**RE: Goodwill at 6530 McMahon Blvd NW
Erosion and Sediment Control Plan
Engineer's Stamp Date 12/16/25 - A10E002G_BP –(SWQ-2025-00068)**

Based on the information in your submittal received on 12/17/25, the above-referenced ESC Plan and NOI cannot be approved until the following comments are addressed.

Sheet: EROSION CONTROL PLAN (SHEET 1 OF 2)

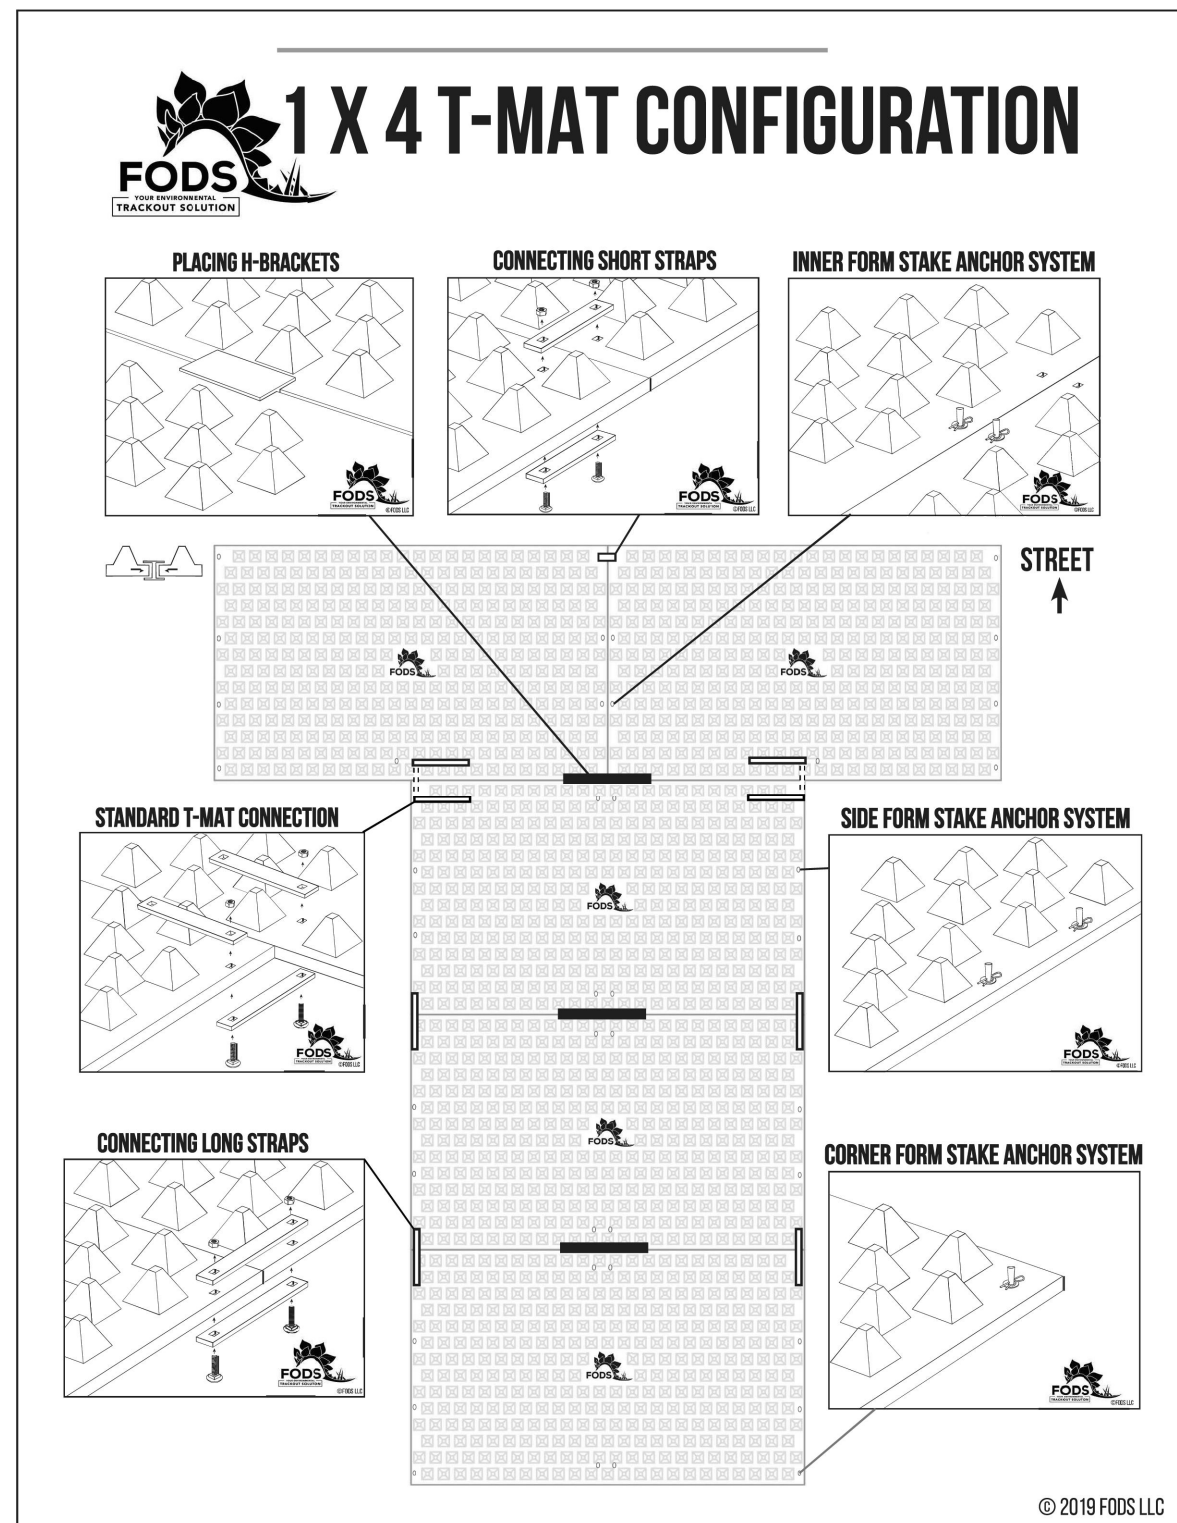
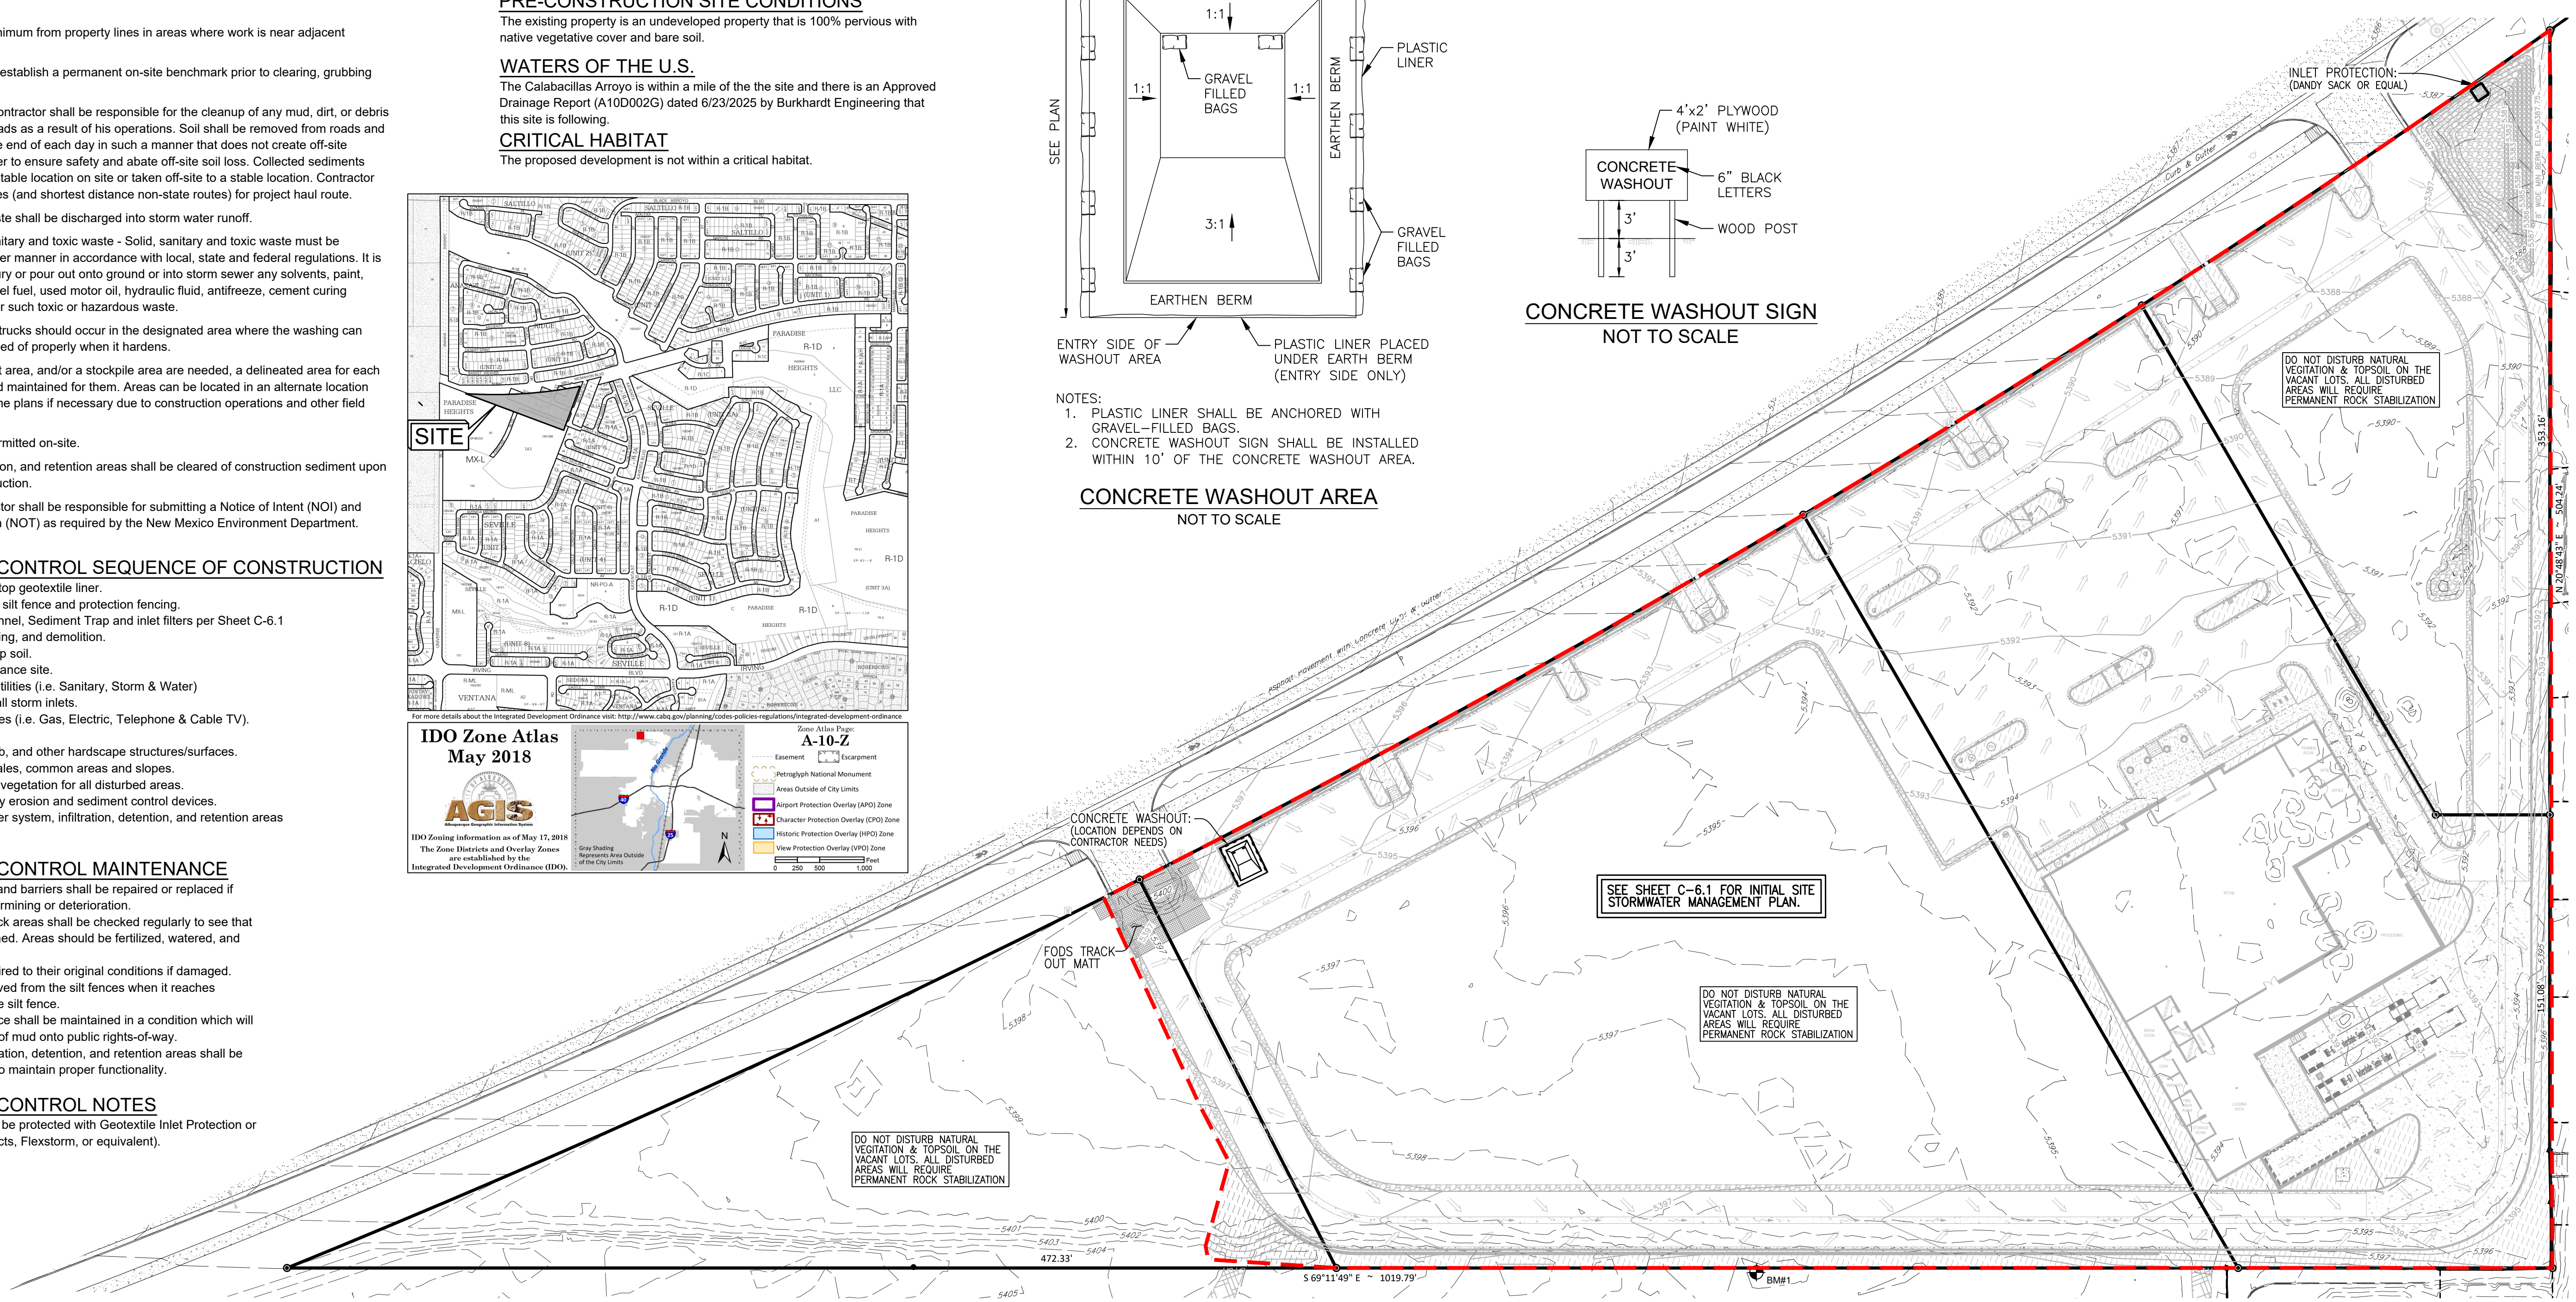
2. The silt fence is the only stormwater control specified downgradient from the land disturbing activities. The north edge of the site is downgradient from land-disturbing activities, and the north edge falls more than ten feet from west to east. So, the silt fence there isn't "on contour" as required by the design specifications and good engineering practices, in defiance of CGP 2.1.3 and 9.6.1.c.i and 9.6.1.c.iii. You must "*design and install all stormwater controls in accordance with good engineering practices, including applicable design specifications*" per CGP 2.1.3. The NMED requirements in CGP 9.6.1.c.i state: "*The SWPPP must also describe design specifications, construction specifications, maintenance schedules (including a long-term maintenance plan), criteria for inspections, and expected performance and longevity of these BMPs. For sites greater than 5 acres in size "BMP selection must be made based on the use of appropriate soil loss prediction models or equivalent generally accepted soil loss prediction tools,"* and part 9.6.1.c.iii states: "*All SWPPPs must be prepared in accordance with good engineering practices by qualified (e.g., CPESC certified, engineers with appropriate training) erosion control specialists familiar with the use of soil loss prediction models and design of erosion and sediment control systems based on these models.*" Documentation is required on the ESC Plan.

You must design stormwater controls specific to this site in accordance with standard design specifications and good engineering practice. For example, you may provide design calculations and construction specifications for a temporary Diversion Channel (DC) along the north edge and a temporary Sediment Trap (ST) at this site's discharge point in the northeast corner that demonstrate compliance with CGP 2.2.12. A silt fence may also be required along the north edge for fugitive dust control, but it isn't considered an acceptable stormwater control due to the slope there. The design calculations should be accompanied by a map of the area(s) draining to the Sediment Trap(s). The DC and ST also need to be in the construction sequence.

4. Remove the Construction Exit from the low corner of the site in accordance with good engineering practices. The low corner is the muddiest location on the site.

6. The SWPPP must include site-specific interim and permanent stabilization as per CGP 9.6.1.c.i. The landscape plan lacks a legend, and stabilization specifications are missing for most areas outside of Goodwill's lot. Provide stabilization construction specifications for all land disturbance areas. The note about "permanent lawn" on the ESC Plan doesn't include actual construction specifications.

7. Delete the note on the ESC Plan that says: *"This plan is for reference / general erosion control measures only. The contractor is responsible for providing a separate SWPPP plan for the overall development to submit to the city for approval. Refer to the city approved SWPPP plan before starting construction"* since this plan is being submitted for city approval.
